Right of Light Consulting

28 February 2024

**47 Fernbank Road, Ascot SL5 8HY
BRE Daylight and Sunlight**

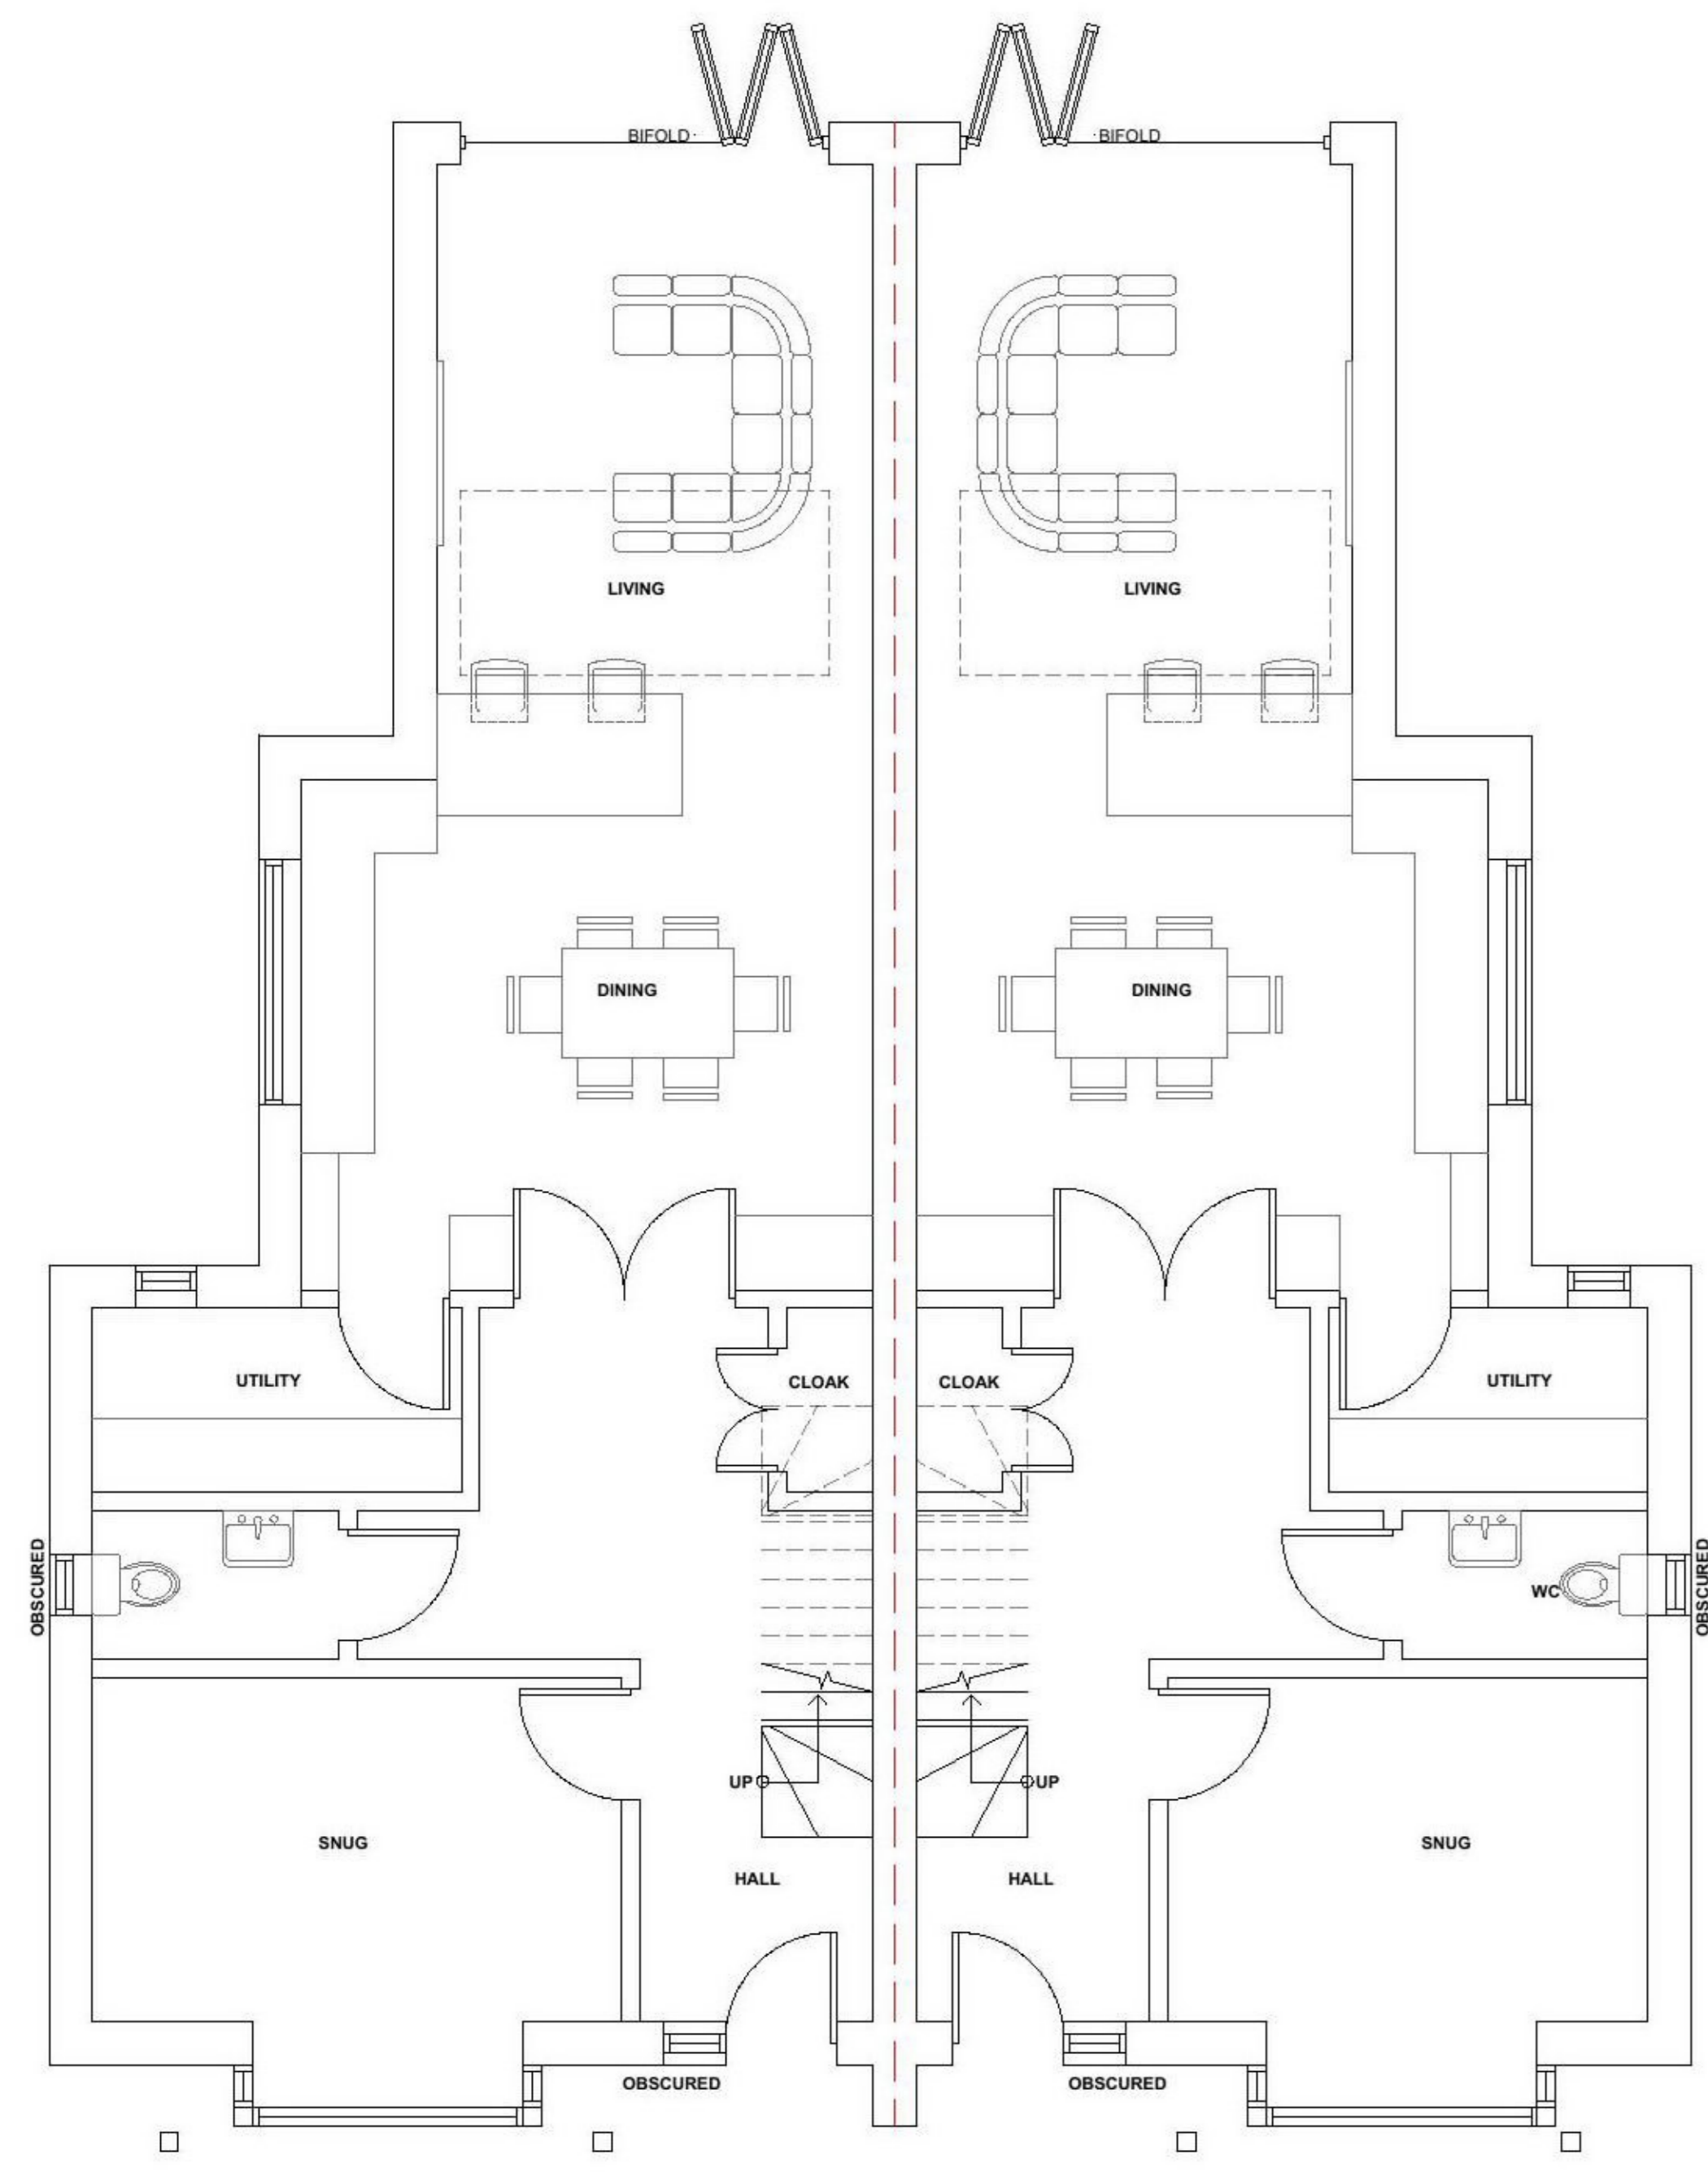
Drawing 120 (enclosed) shows that the proposal satisfies the 45 degree test when applied to the rear elevation window.
